## Stage 1 Road Safety Audit

Proposed Residential Development, Coolagad, Greystones, Co Wicklow

| <b>Document No:</b> | 211517-ORS-XX-XX-RP-TR-7d-001 |

SHEET NUMBER
COO-ACM-00-00-DR-CE-00-0105

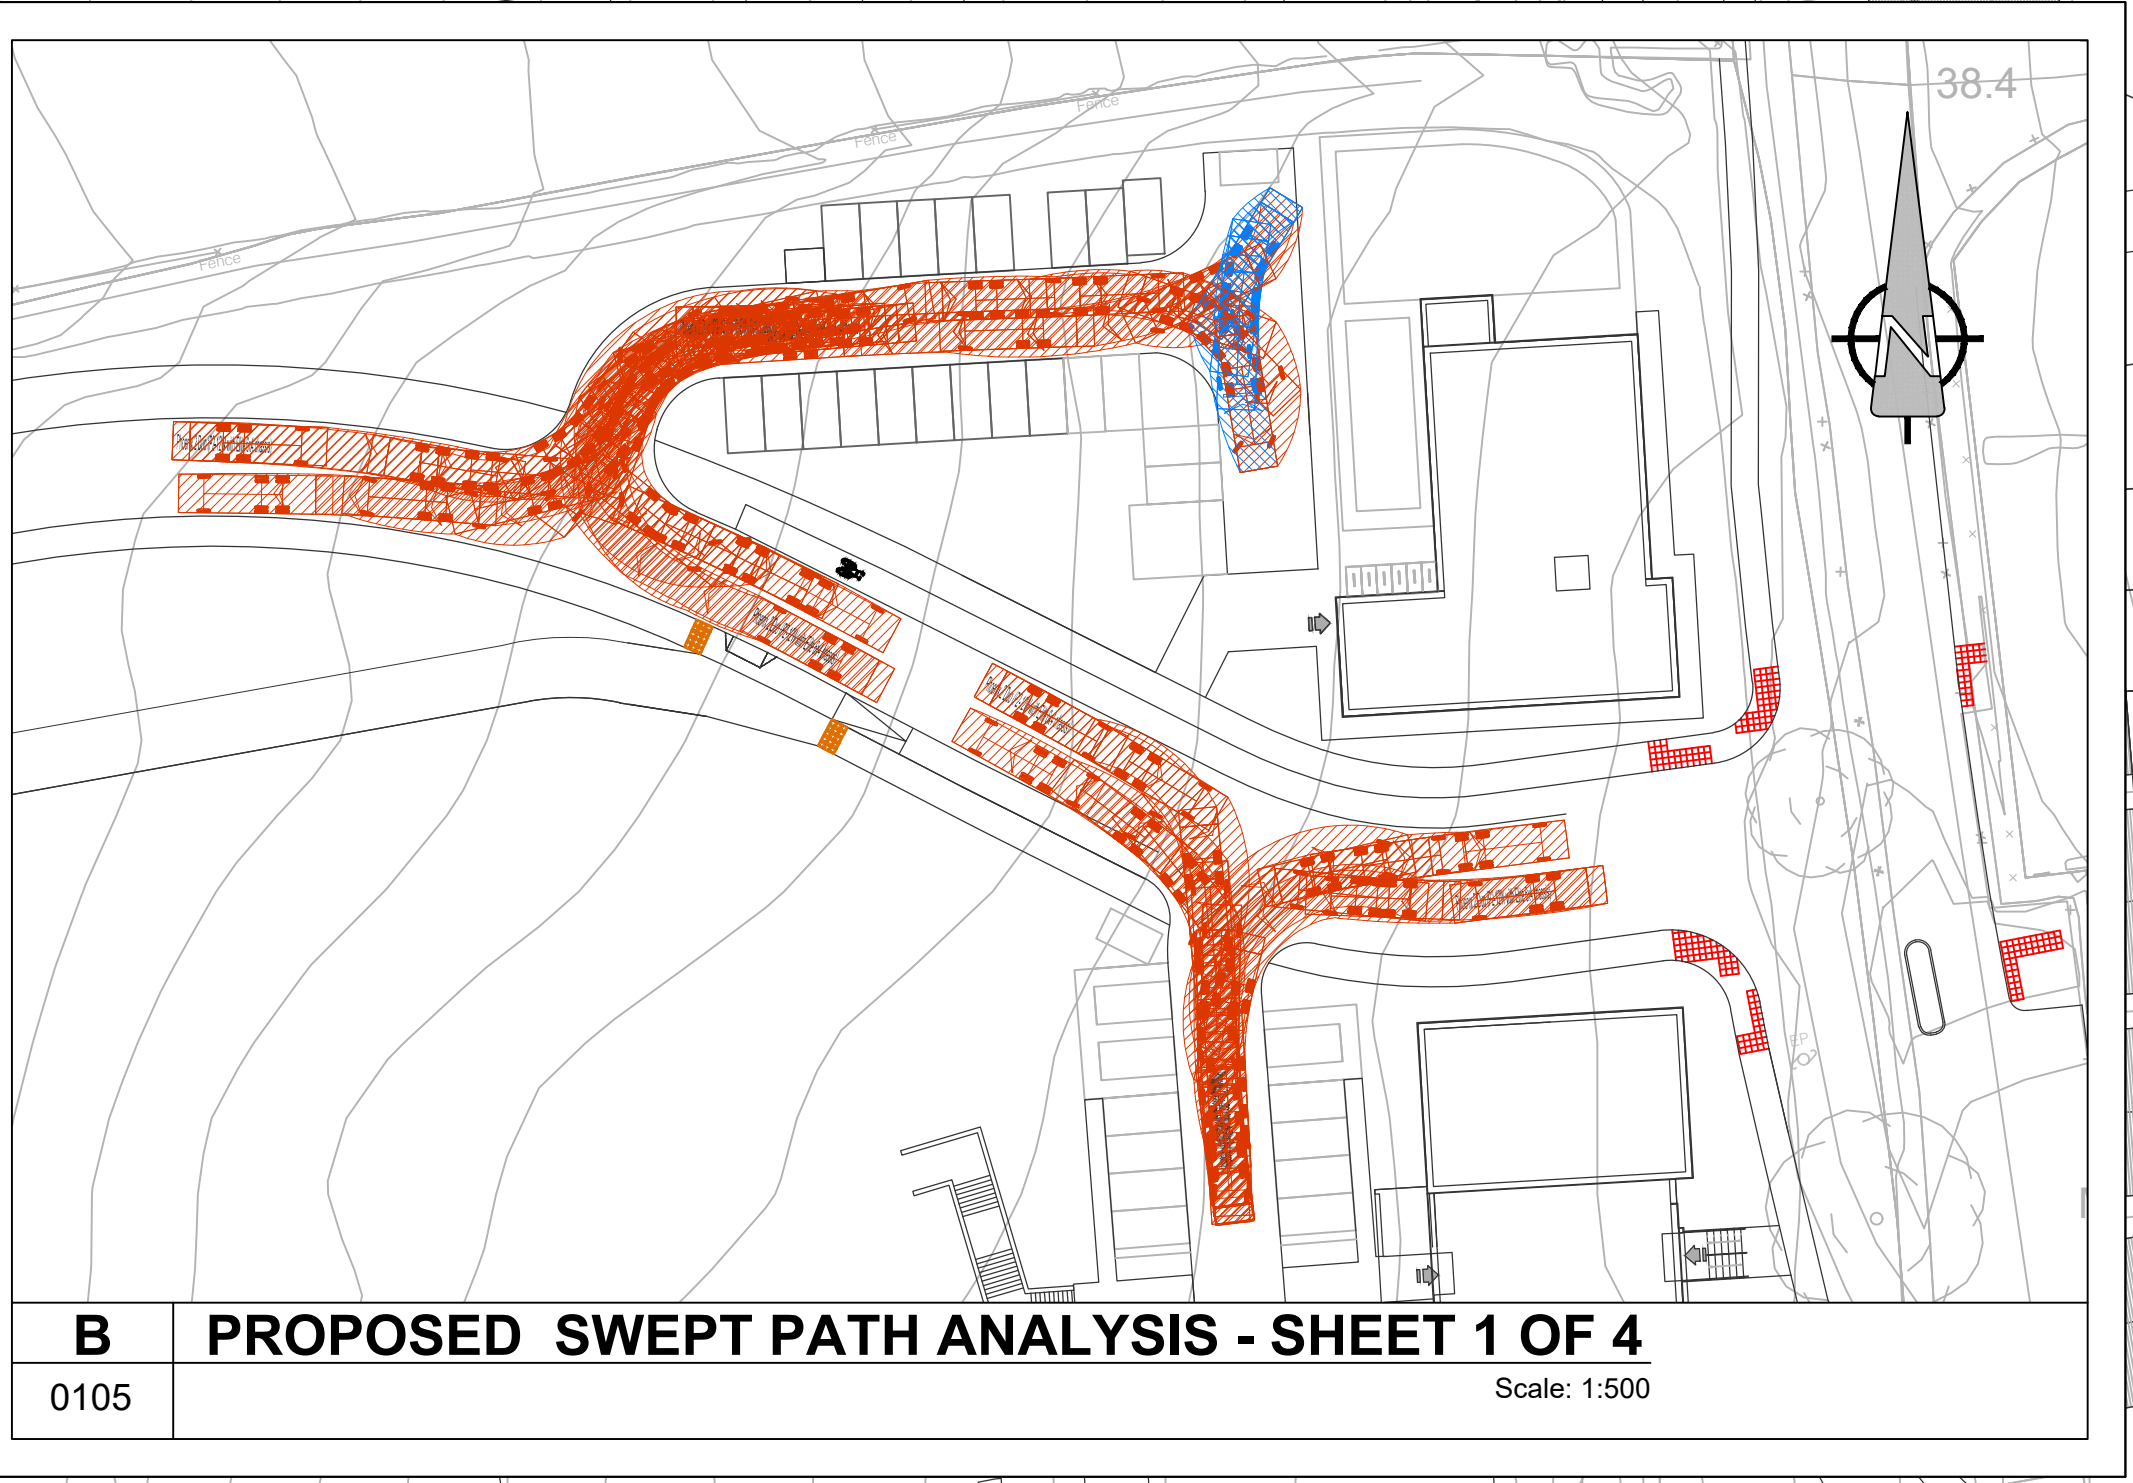
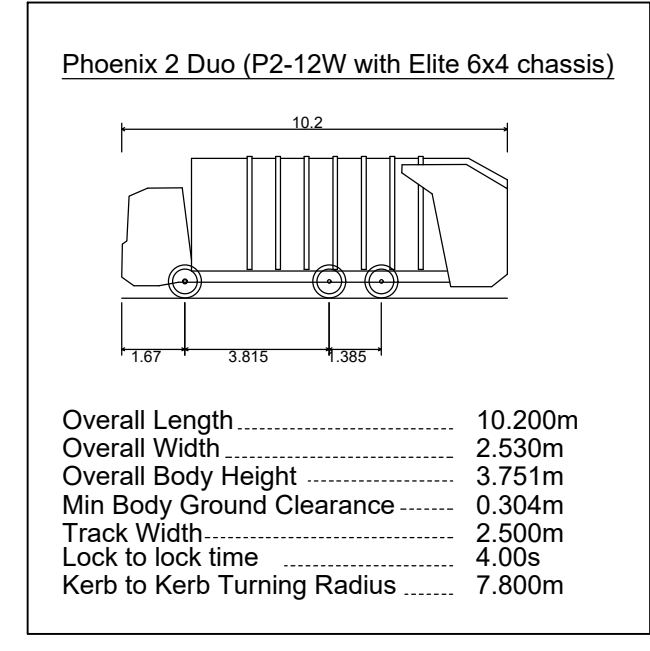
The audit team note from the drawings provided that there are no provisions for vehicle swept path analysis for design vehicles including passenger vehicles, emergency vehicles and service vehicles for the internal circulatory roads. Insufficient kerb radii, turning heads may result in vehicle/vehicle, vehicle/cyclist or vehicle/pedestrian conflicts due to lane encroachment or kerb mounting during turning movements.

The design team should conduct a vehicle swept path analysis for design vehicle movements for the internal road's layout to ensure that all vehicle types that will use the development can be catered for safely.

Refer to drawings COO-ACM-00-00-DR-CE-00-0101 and 0102 for the sight line analysis. Refer to drawings COO-ACM-00-00-DR-CE-00-0105 and 0106 for the bin truck swept path analysis. Refer to drawings COO-ACM-00-00-DR-CE-00-0107 and 0108 for the fire tender swept path analysis.

Public Lighting Layout

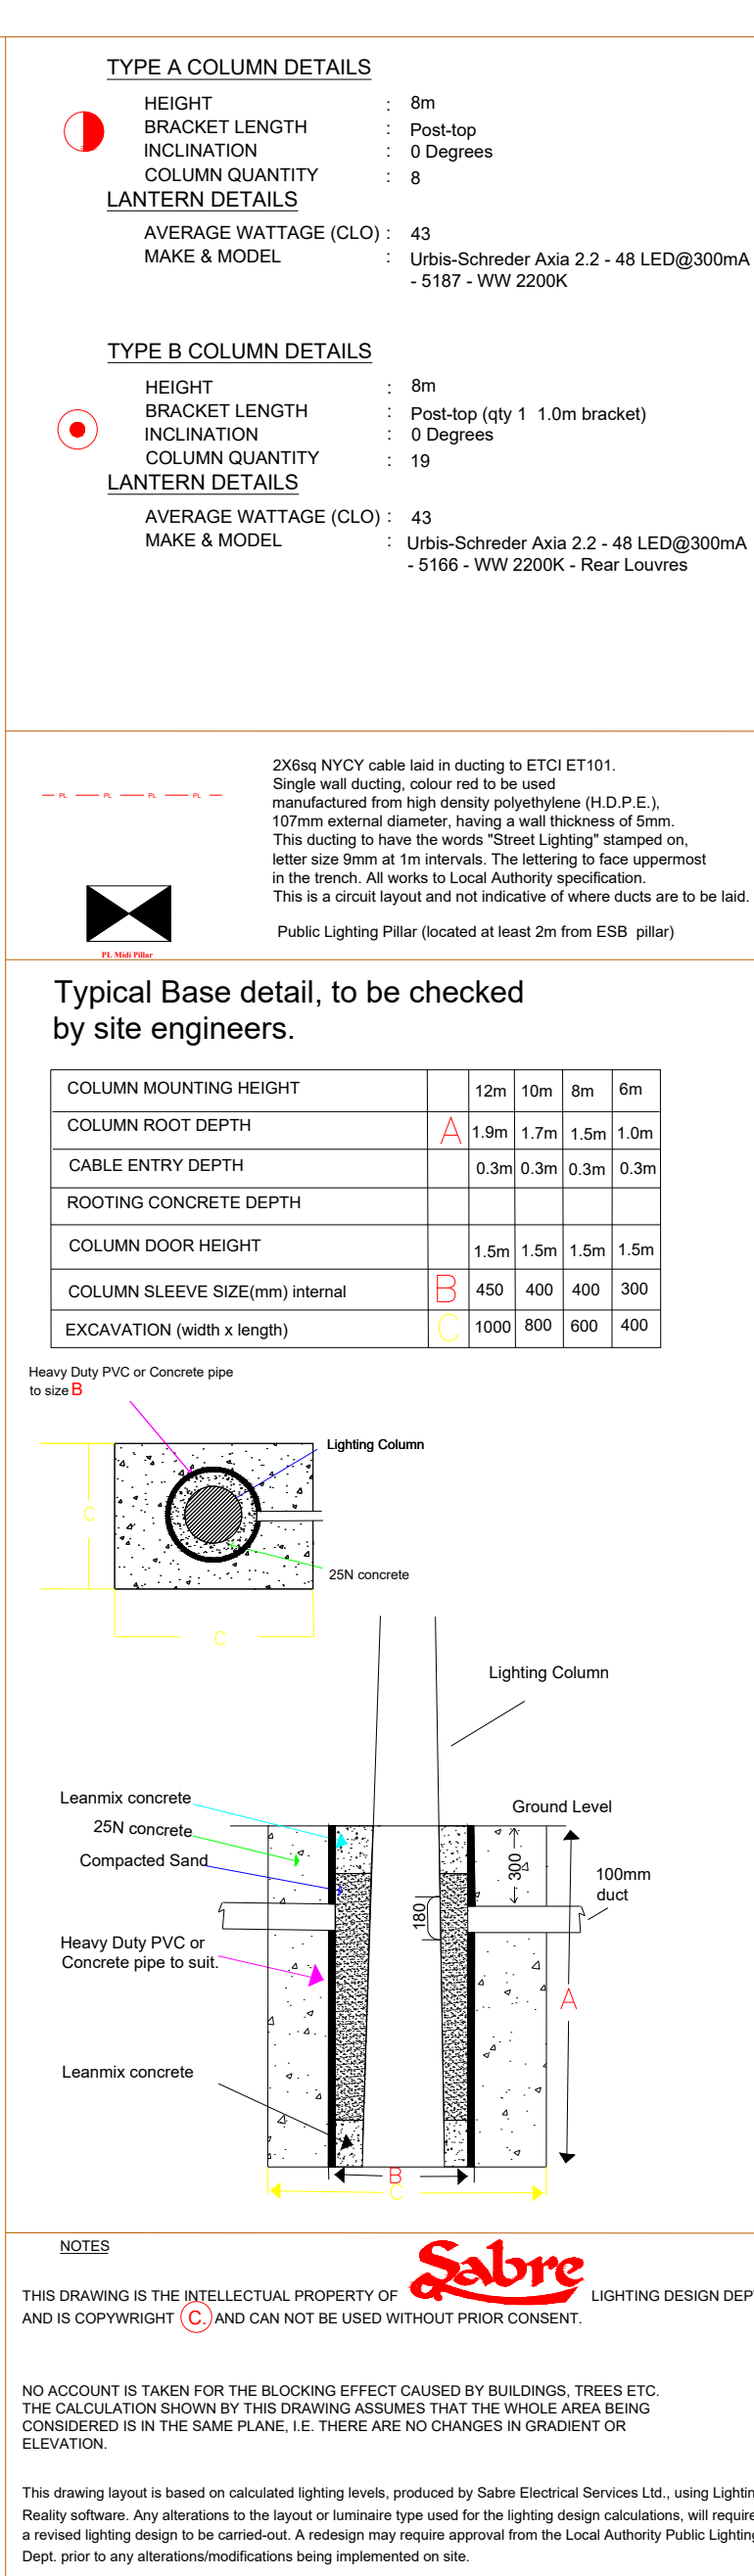
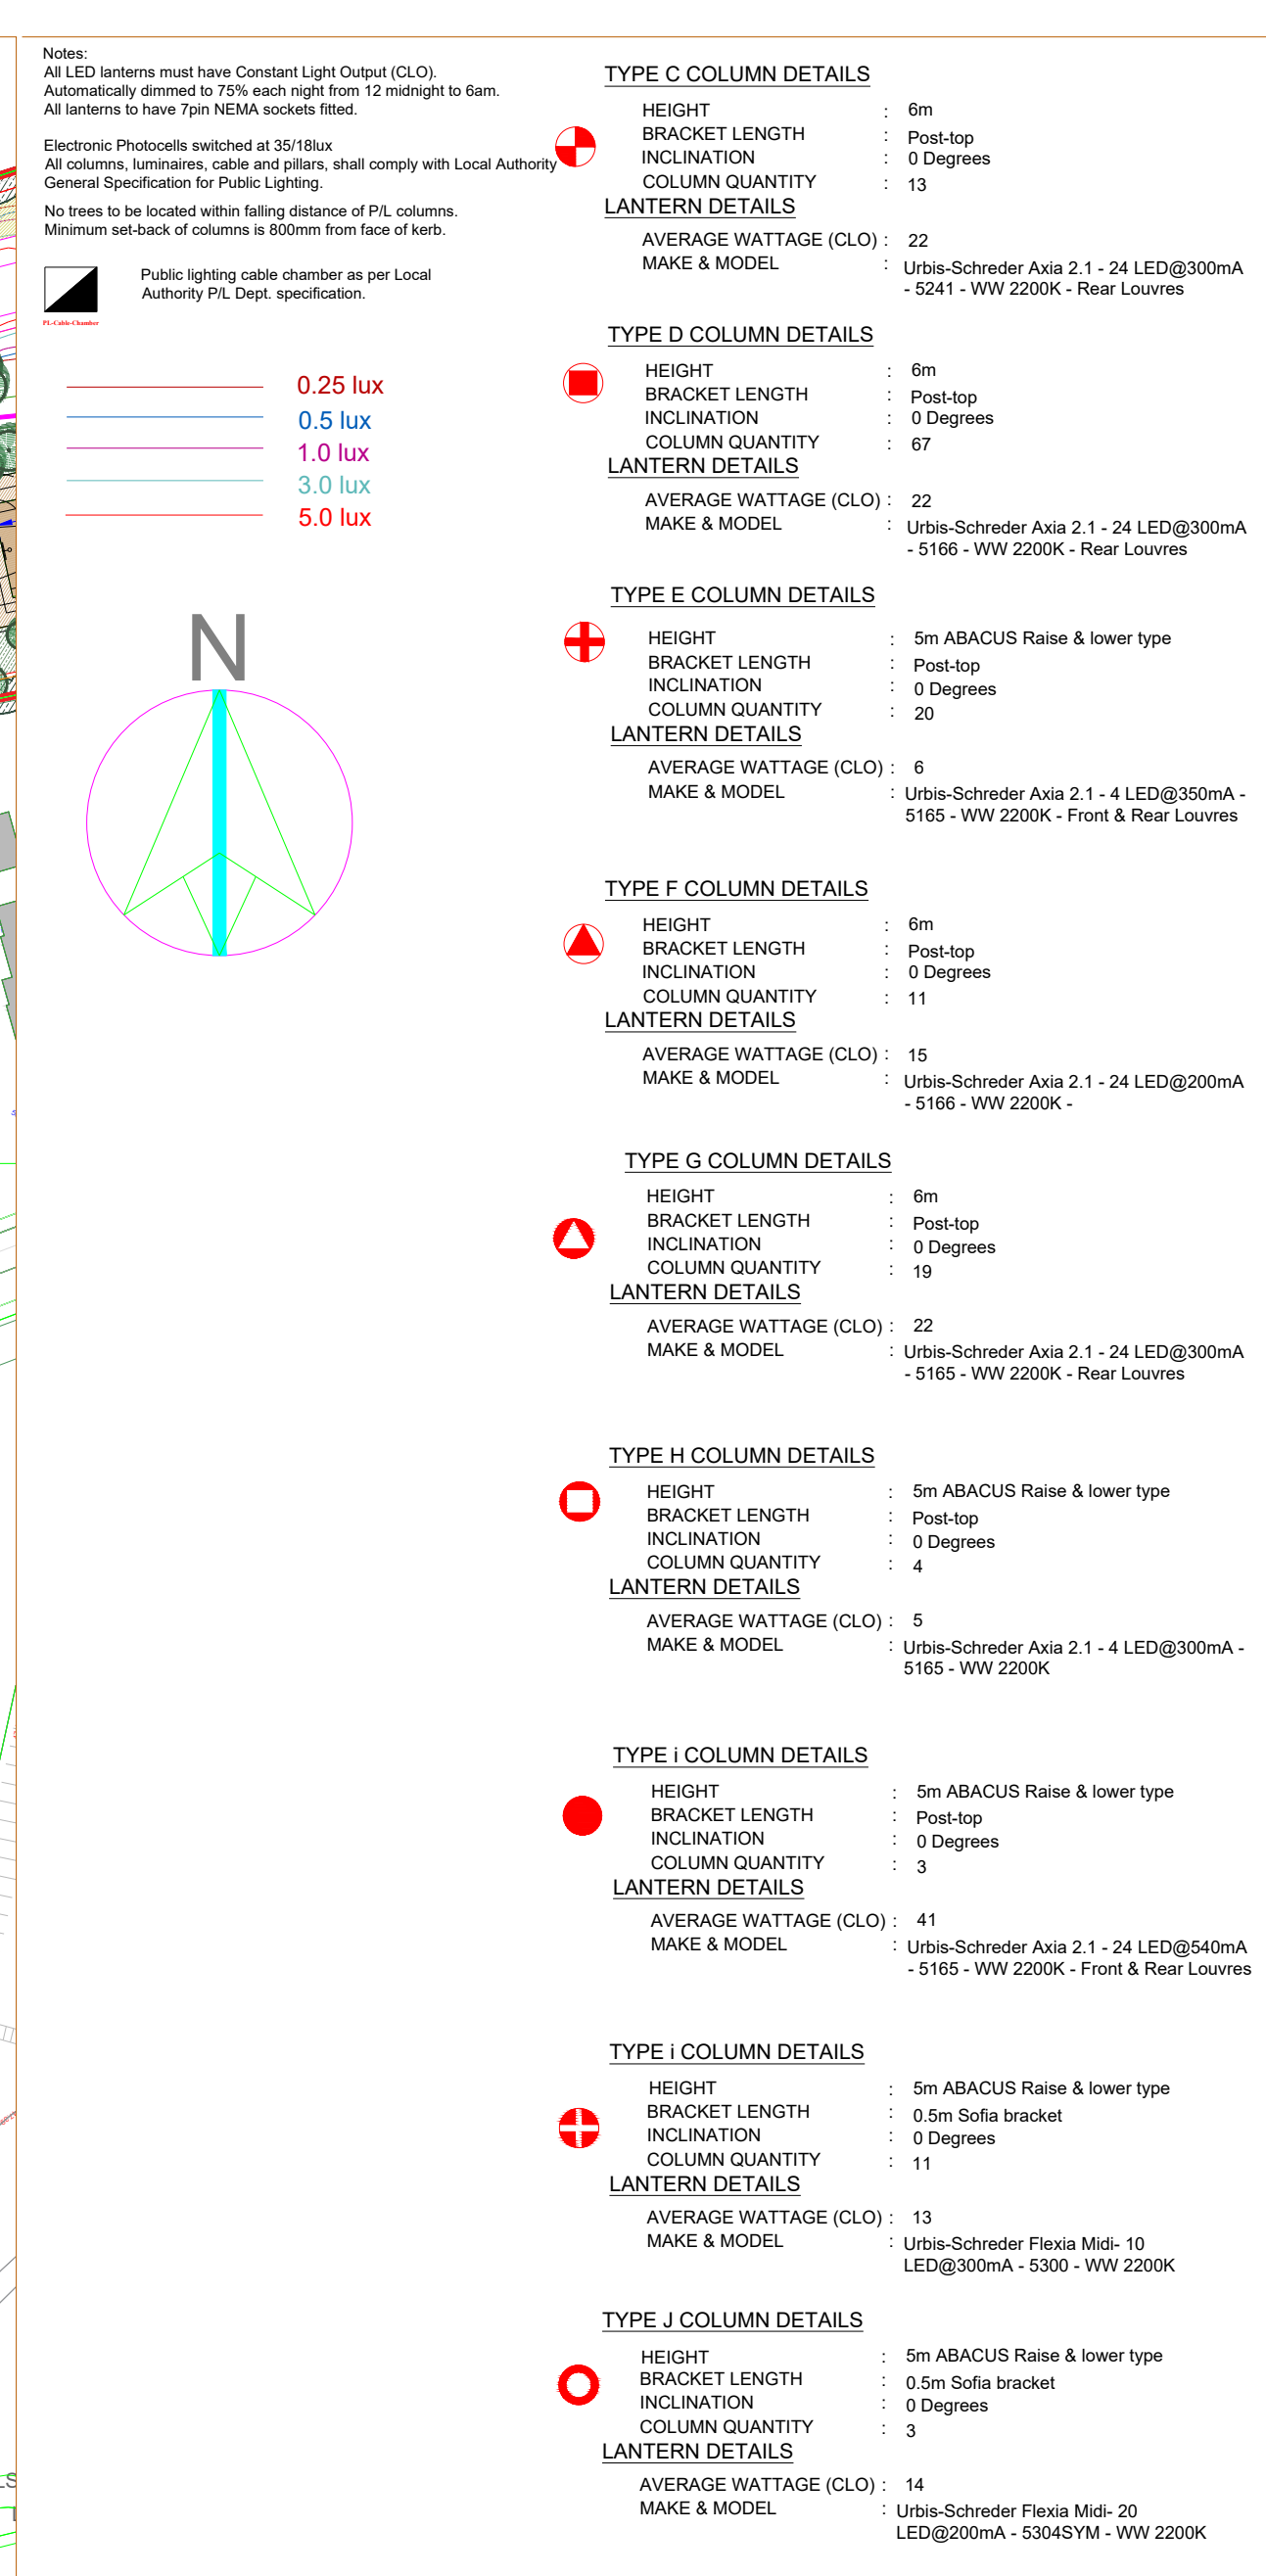
The audit team have not received drawings detailing lighting for the development and the access junction and it is not clear if lighting will be specified for the development. Areas in low light conditions may result in slips trips and falls on pedestrian paths. Drivers may be unable to see pedestrians in the internal road network and at pedestrian crossings which has the potential to lead to pedestrian-vehicle collisions resulting in injury to pedestrians.

The design team should ensure that details and locations of all public lighting columns are provided for at detailed design and to ensure that positioning of columns does not cause any obstruction or hazard to vulnerable users.

The details and locations of all public lighting columns will be provided for at the detailed design stage.
